# One Earth Solar Farm

**Final Statement of Common Ground with Historic England**

**EN010159/APP/8.7.4**

December 2025

**Zone of Theoretical Visibility**

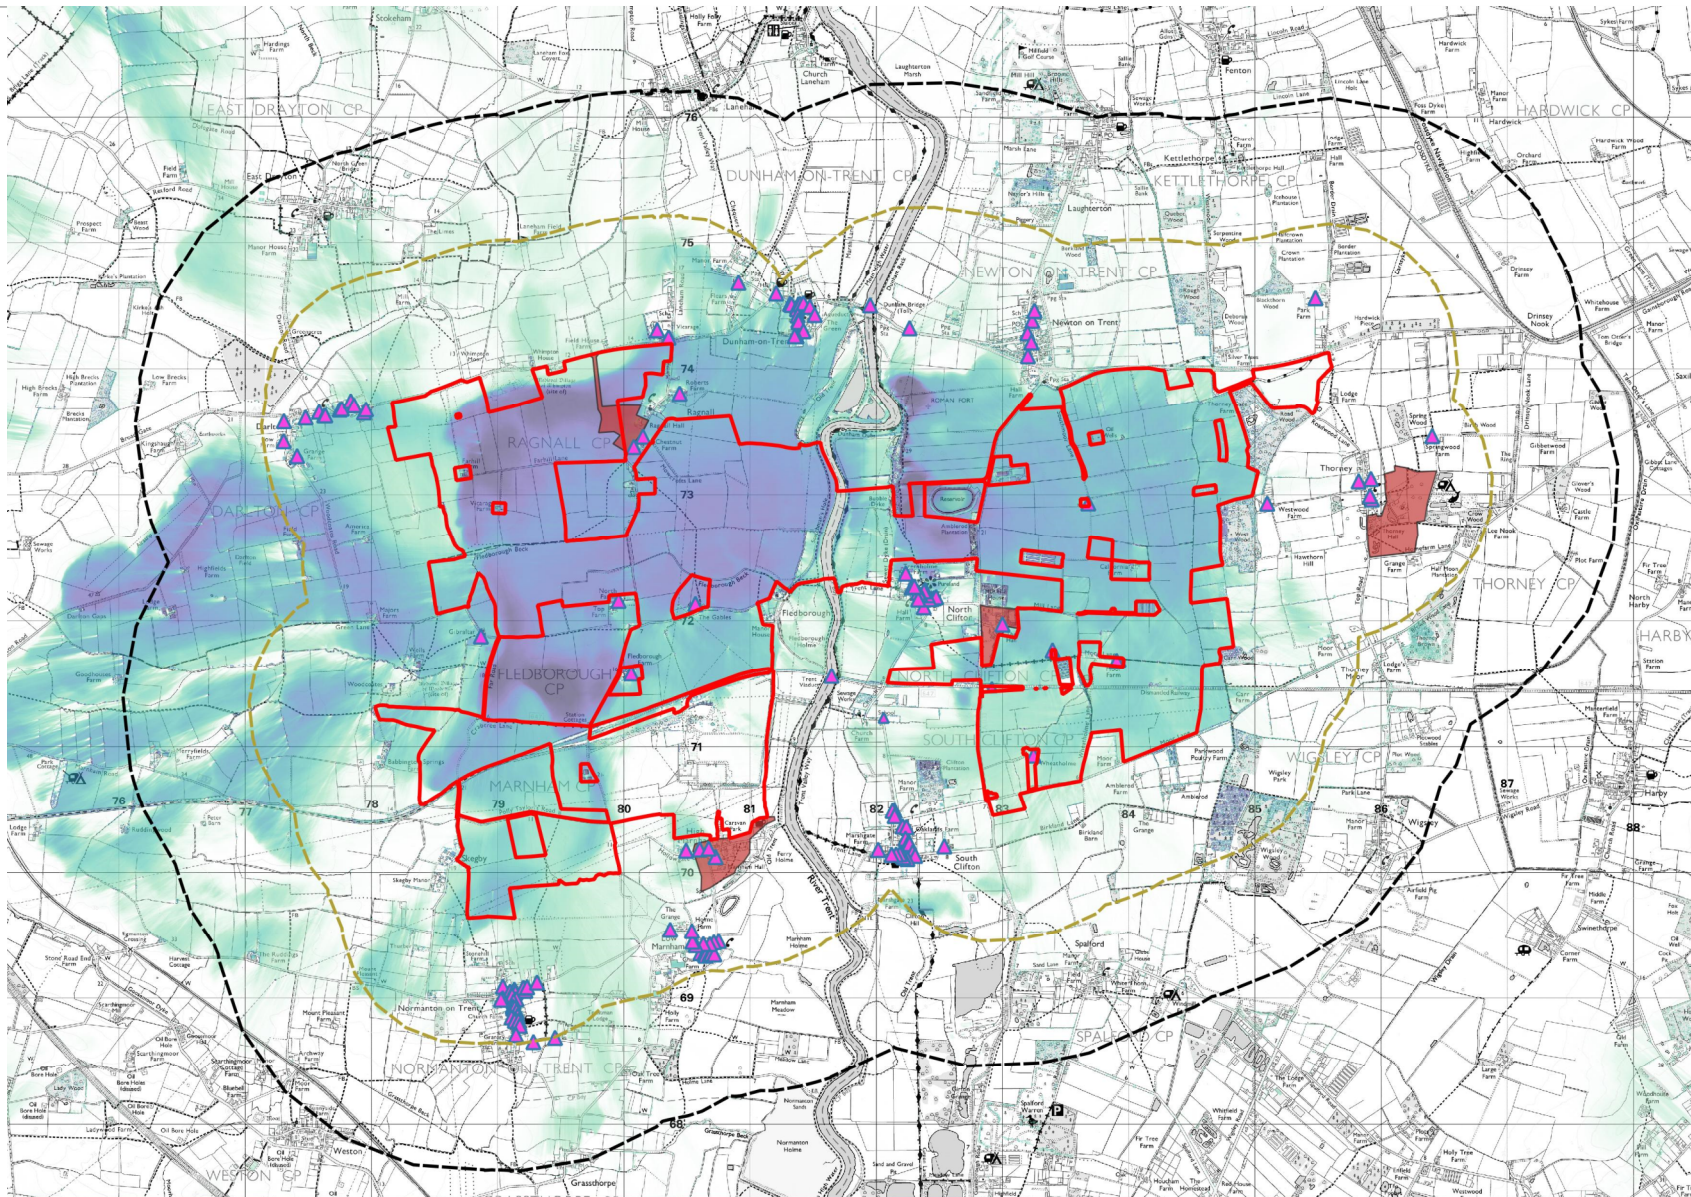
02-06	Impact on setting of built heritage assets	<p>Further understanding required on field to the north of North and South Clifton as viewed from Fledborough Viaduct.</p> <p>Further detail can be found in Historic England's Relevant Representation [RR-019, 190], as well as email correspondence</p>	<p>The understanding of Proposed Development in relation to North and South Clifton is supported by LVIA photomontages (Views 25a, Figure 11.13.7a, [AS-038]) and Zone of Theoretical Visibility (Figure 10.3 [APP-055]). The effect on heritage assets within North and South</p>	Agreed

in December 2024 – January 2025.	Clifton is provided in pages 51-53 and page 57 of ES Chapter 10 [APP-039]. There are no harmful effects identified to these assets.	
02-07	Mitigation	<p>Historic England have requested for mitigation to be provided at western substation (Gibraltar Farm) and consideration of associated impacts, i.e. lighting.</p> <p>Further detail can be found in Historic England's Relevant Representation [RR-019, 190], as well as email correspondence in December 2024 – January 2025.</p>	The mitigation for Gibraltar Farm has been clarified at 10.5.5 of ES Chapter 10 [APP-039], and the assessment has been provided at 10.6.65 - 67. The mitigation provided is considered to be proportionate to the very low value of this asset. And this location is considered preferable to others, as per the response to comment 02-02 above.	<b>Agreed</b>
02-08	Impact on setting of heritage assets	<p>Historic England raised concerns on the proximity of the solar panels to the south of Whimpton Moor SM. Larger buffer suggested, "possibly by removing the triangular area of panels to the brown line indicated on the masterplan".</p> <p>Further detail can be found in Historic England's Statutory Consultation Response (reference can be provided upon</p>	Further detail can be found in Table 10.5 of ES Chapter 10: Cultural Heritage [APP-039]. The effect on Whimpton Moor Scheduled Monument has been assessed in ES Chapter 10 at 10.6.39 – 41 [APP-039]. Whilst there would be harm to the significance of Whimpton Moor from Development in its setting, this would be less than substantial in the middle of the spectrum (minor-moderate adverse	<b>Agreed</b>
